SITE PLAN
SCALE: 1"=30'-0"

Added PCD File No. PPR2111

CBP 2-1, LOT 3
7755 GARY WATSON POINT
COLORADO SPRINGS, CO 80915
EL PASO COUNTY, COLORADO

SITE PLAN
 SCALE: 1"=30'-0"

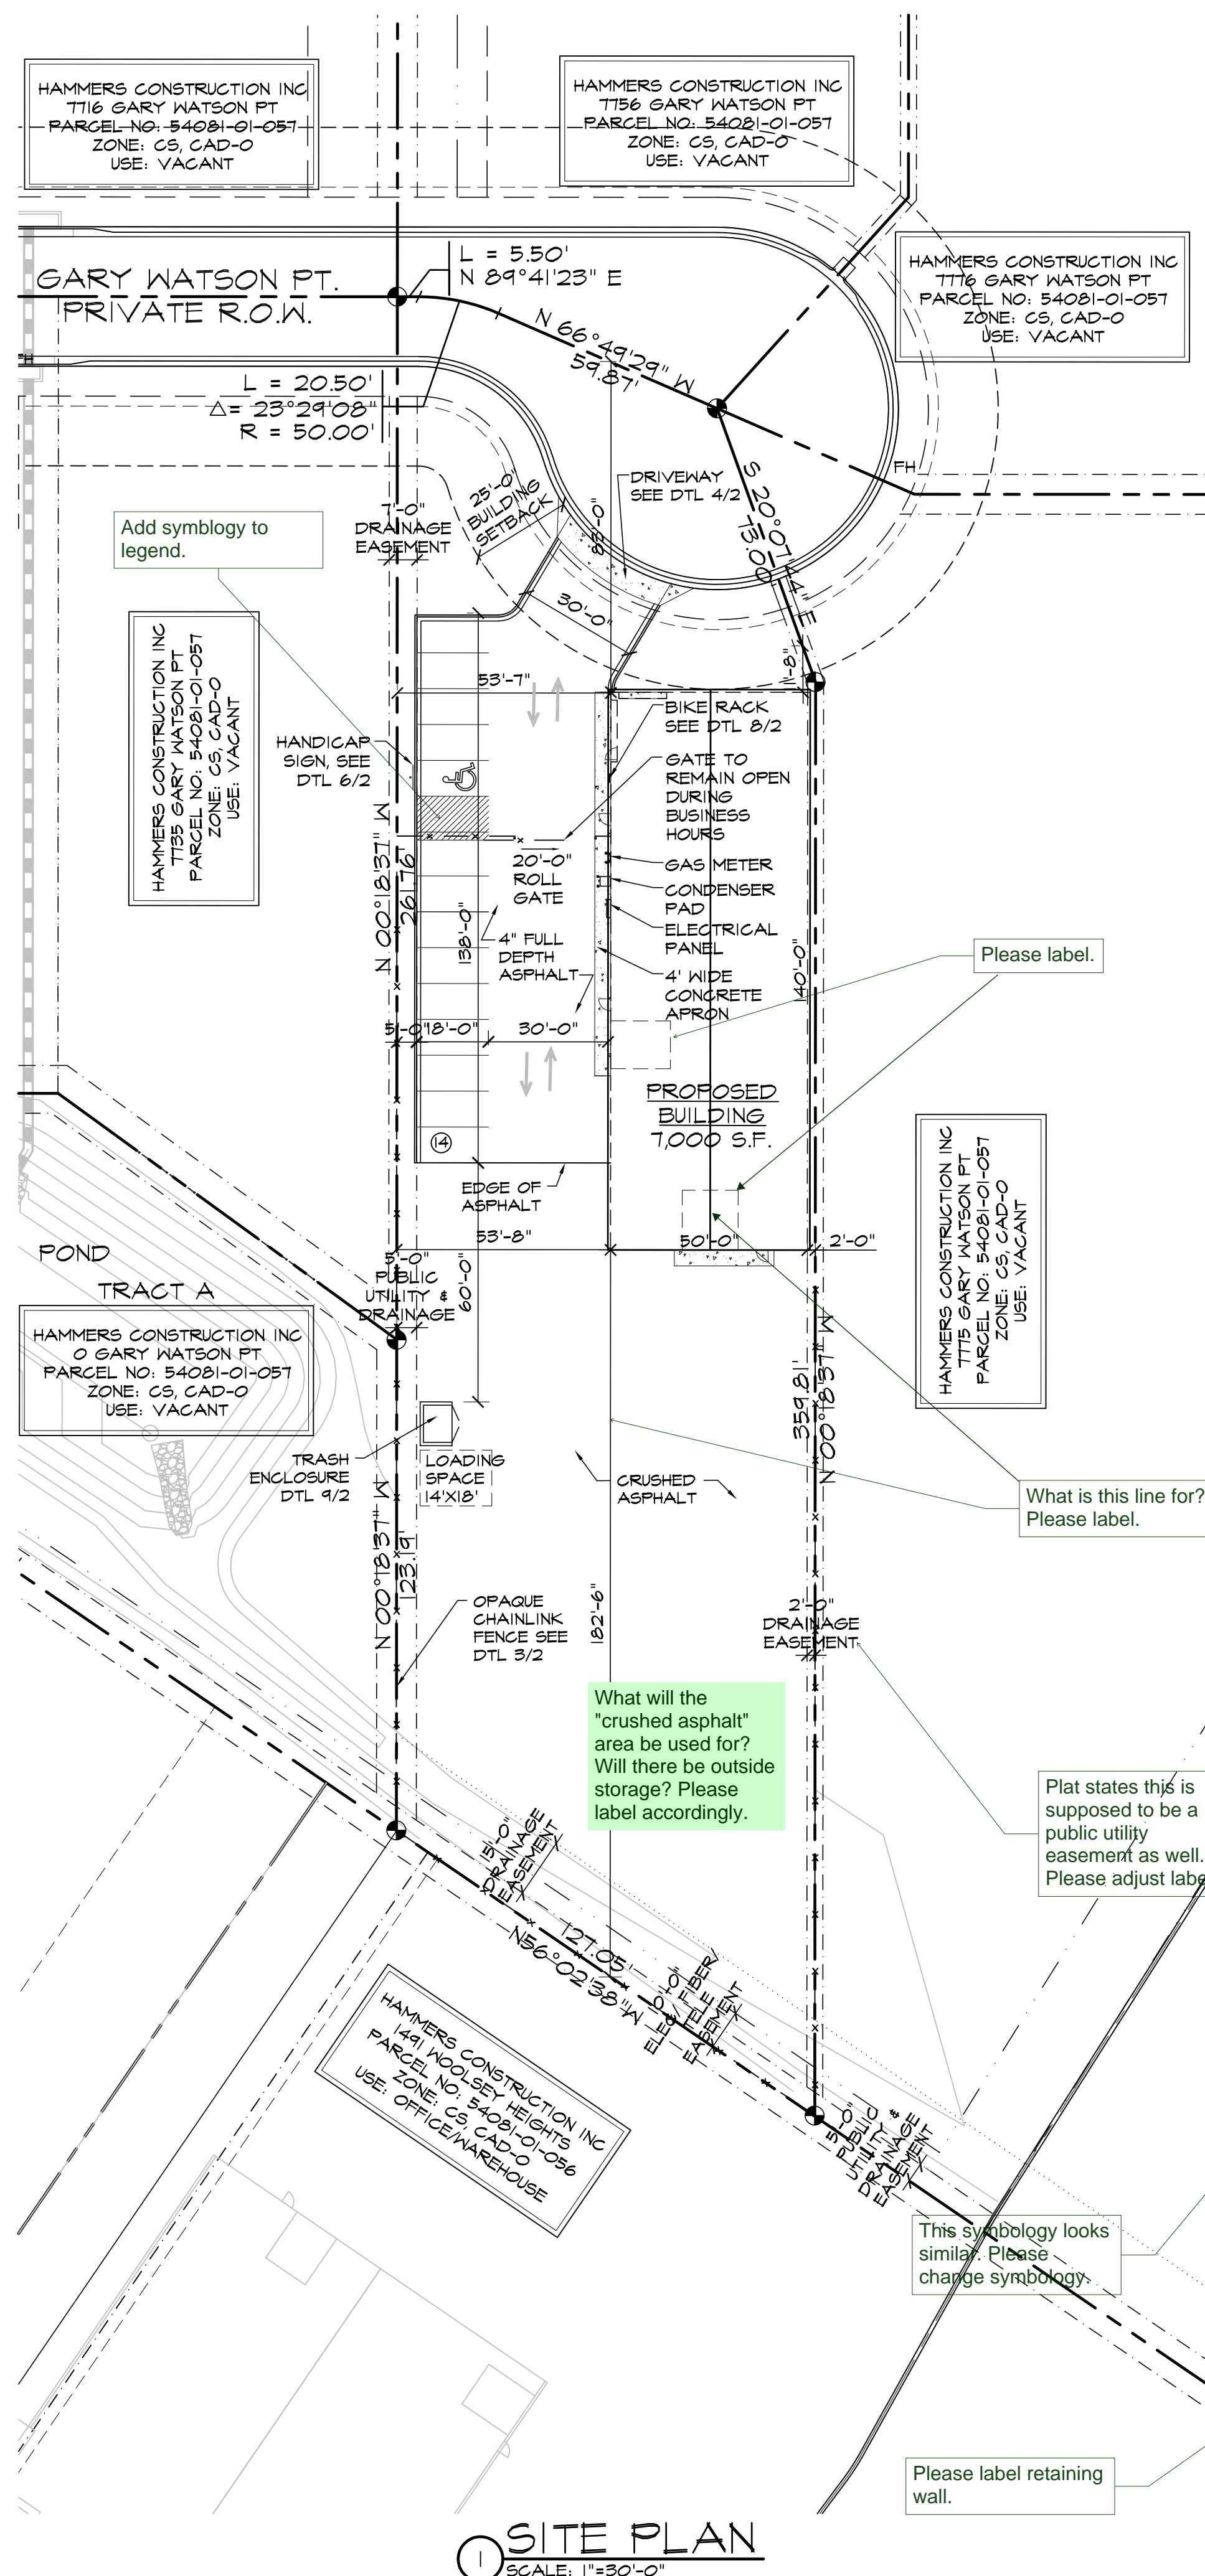
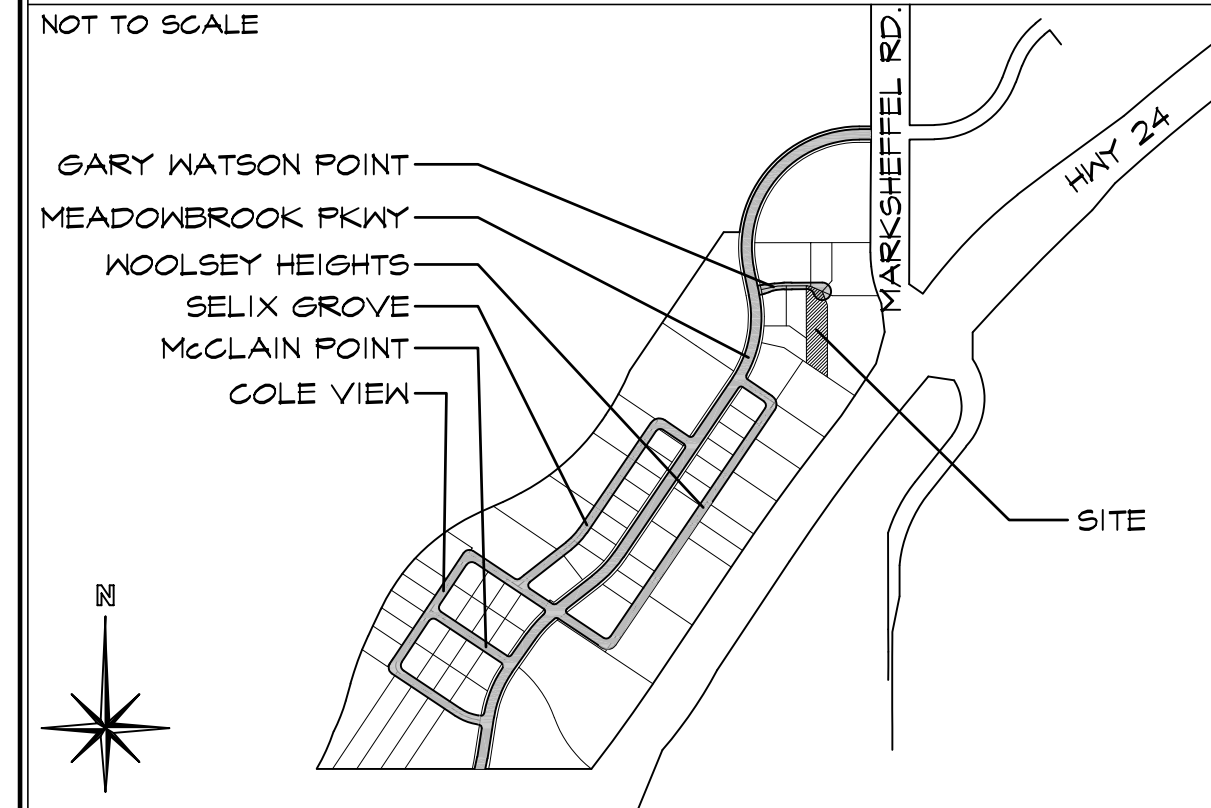
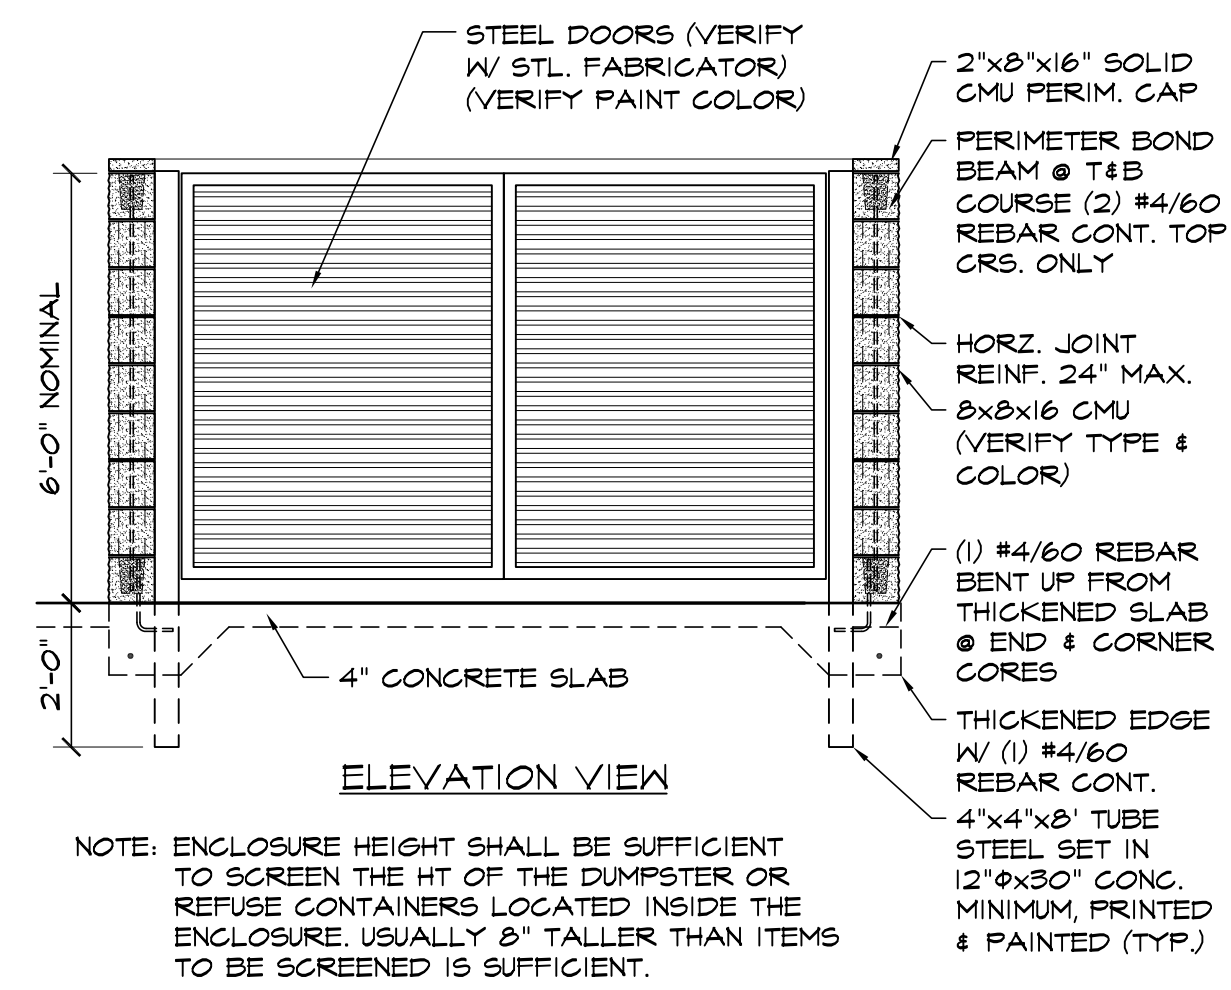
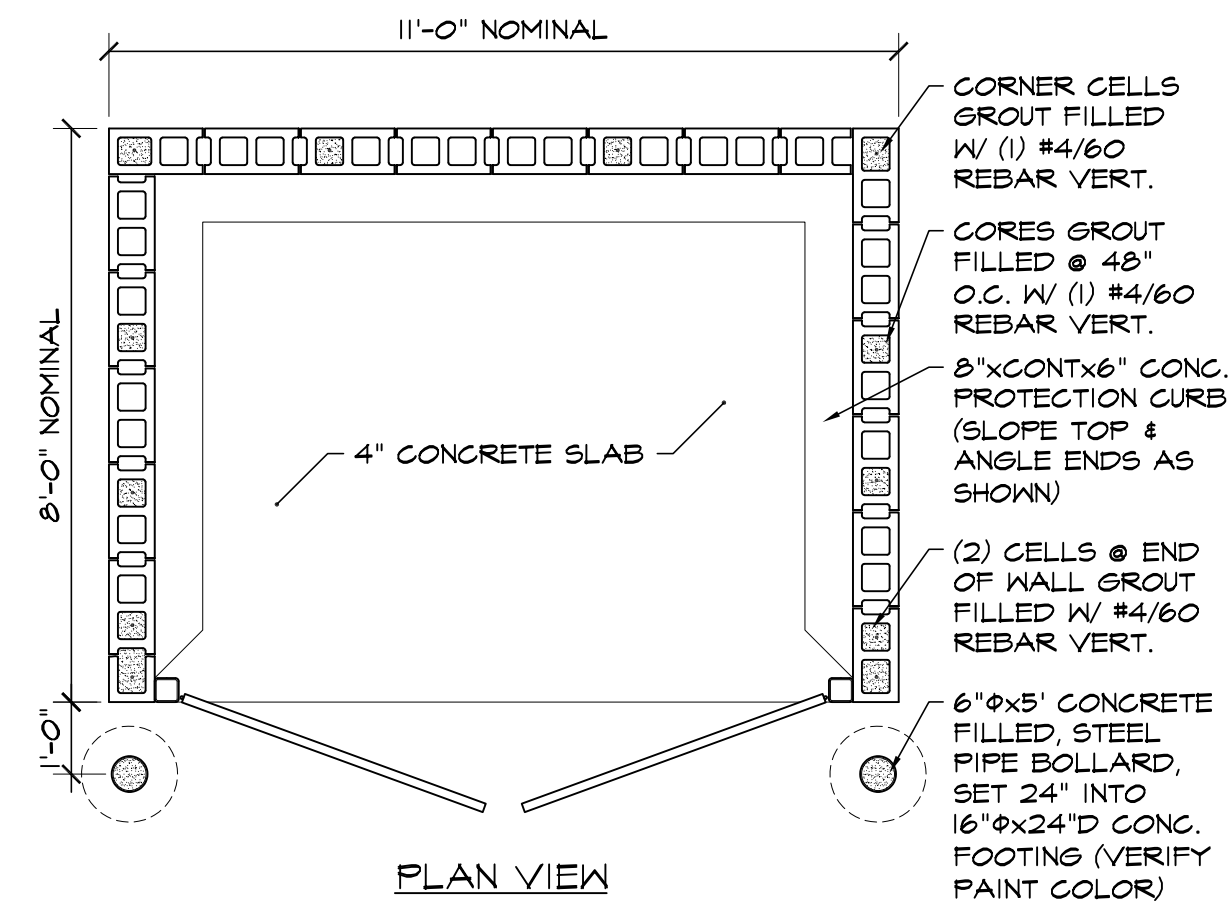
Add symbology to legend.
This is a van accessible area. We feel this is not necessary to add to the legend as this is standard striping designation for any parking lot. This hatch always refer to a no parking area. Furthermore, we show this detailed in our parking detail located on page 2, detail 1

Please label.
The dashed lines are our overhead door locations. The middle line is our ridge line. We have been doing plans in EPC for 30 years and have never had to call this out before. We feel this is labeled adequately with the remaining plan set, via building elevations and floor plan. We like to keep our plan sets consistent and we have already gotten 3 plans approval without this label within this subdivision. Therefore, we feel these labels are not needed.

What is this line for? Please label.
The middle line is our ridge line. The other line is a dimension line. We have been doing plans in EPC for 30 years and have never had to call this out before. We feel this is labeled adequately with the remaining plan set, via building elevations and floor plan. We like to keep our plan sets consistent and we have already gotten 3 plans approval without this label within this subdivision. Therefore, we feel these labels are not needed.

What will the "crushed asphalt" area be used for? Will there be outside storage? Please label accordingly.
Crushed asphalt is a cost savings to keep erosion measures down and give a more finished look. There will be no outside storage. This area will be for vehicle turn around. If a client decides to store at a later date, they will be responsible for providing screening and going through special use process if it is warranted

Plat states this is supposed to be a public utility easement as well. Please adjust label.
Corrected

This symbology looks similar. Please change symbology.
We have been doing plans in EPC for 30 years and have kept this legend the same, we have never had an issue with previously approved plans. We like to keep our plans consistent and feel this change is not needed. In addition, we label these setbacks for further clarification

Please label retaining wall.
No retaining wall is proposed. This is our standard legend. We have removed this label for clarity.

8 BIKE RACK DETAIL
SCALE: 1/2"=1'-0"

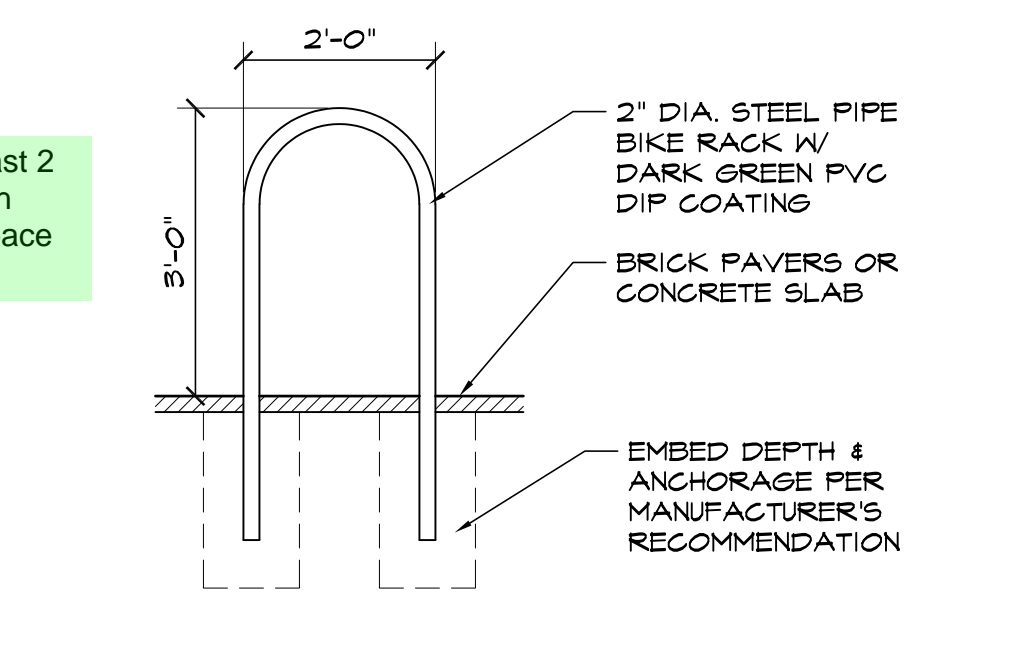
Bicycle parking facilities shall be at least 2 feet in width and 5 1/2 feet in length, with additional back-out or maneuvering space of at least 5 feet.

Noted
